RE: 6/2018/2150/MAJ - University of Hertfordshire De Havilland Campus, Hatfield, AL10 9UF

Thank you for consulting us on the above application for the erection of three storey business and social building, associated drainage, landscaping and ancillary works, at University of Hertfordshire, de Havilland Campus, Hatfield, AL10 9UF.

We understand this application seeks full planning permission for a major development, and we have assessed the Drainage Strategy Report prepared by Conisbee, reference 180149/J Courtney, revision 1.0, dated 14th August 2018, submitted to support to this application. However the information provided to date does not provide a suitable basis for an assessment to be made of the flood risks arising from the proposed development.

**Design Notes:**

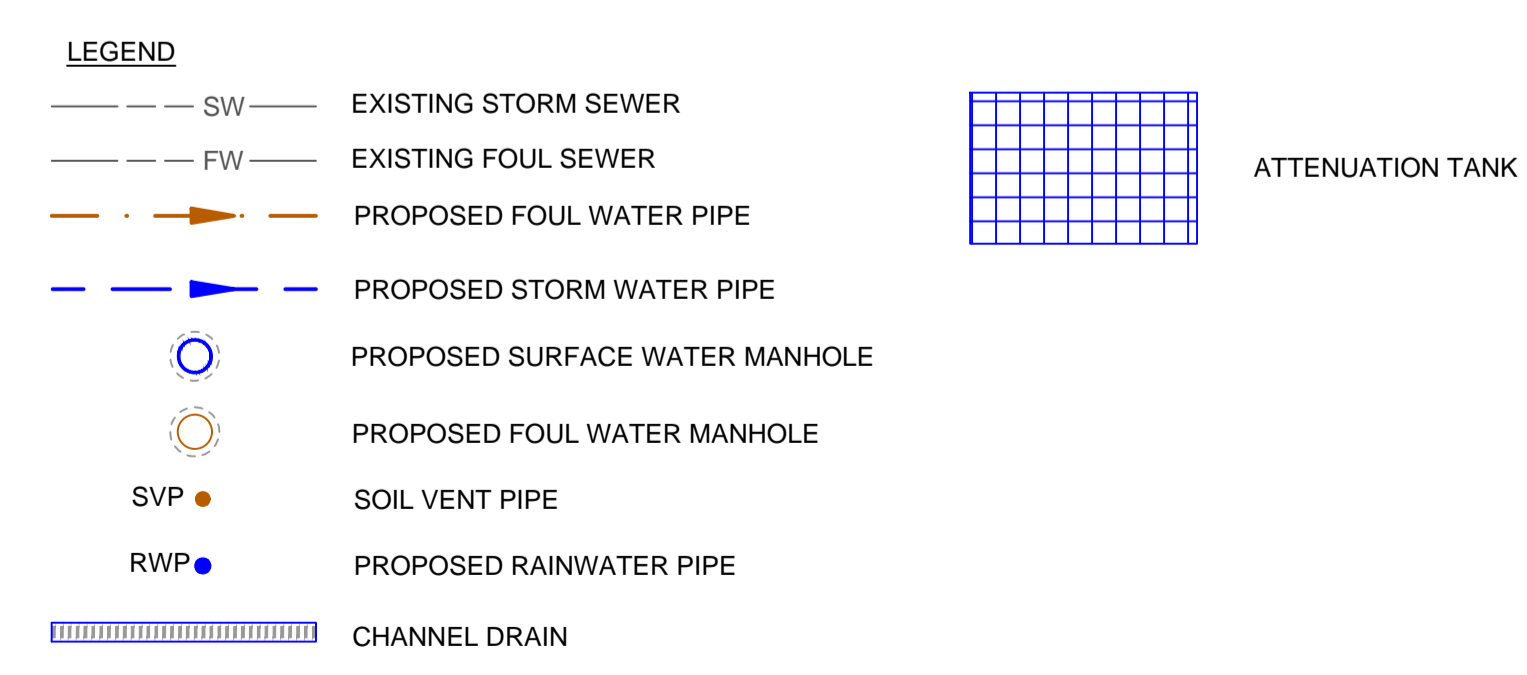
1. We acknowledge the existence of the Drainage Strategy Report. We note that the applicant intends to limit the final discharge from the site to 5 l/s.

As the LLFA, we would expect the applicant to limit the final discharge from the site to Greenfield run-off rates. We are aware that there are new devices available in the market, which will allow securing the final discharge rate from the site below 5 l/s.

We understand that the final discharge point from the site for surface water run-off is Ellen Brook. We are aware as well that there are downstream flooding problems within this river. Therefore, the final discharge from the site should be at Greenfield run-off rates.

In line with the above we would expect the applicant to update and submit the drainage report including updated modelling and drainage layout.

2. We acknowledge that the applicant intends to implement underground storage solutions only. We note as well that the existing area is a Greenfield site. Therefore, we expect the applicant to explore above ground storage solutions for the proposed development.
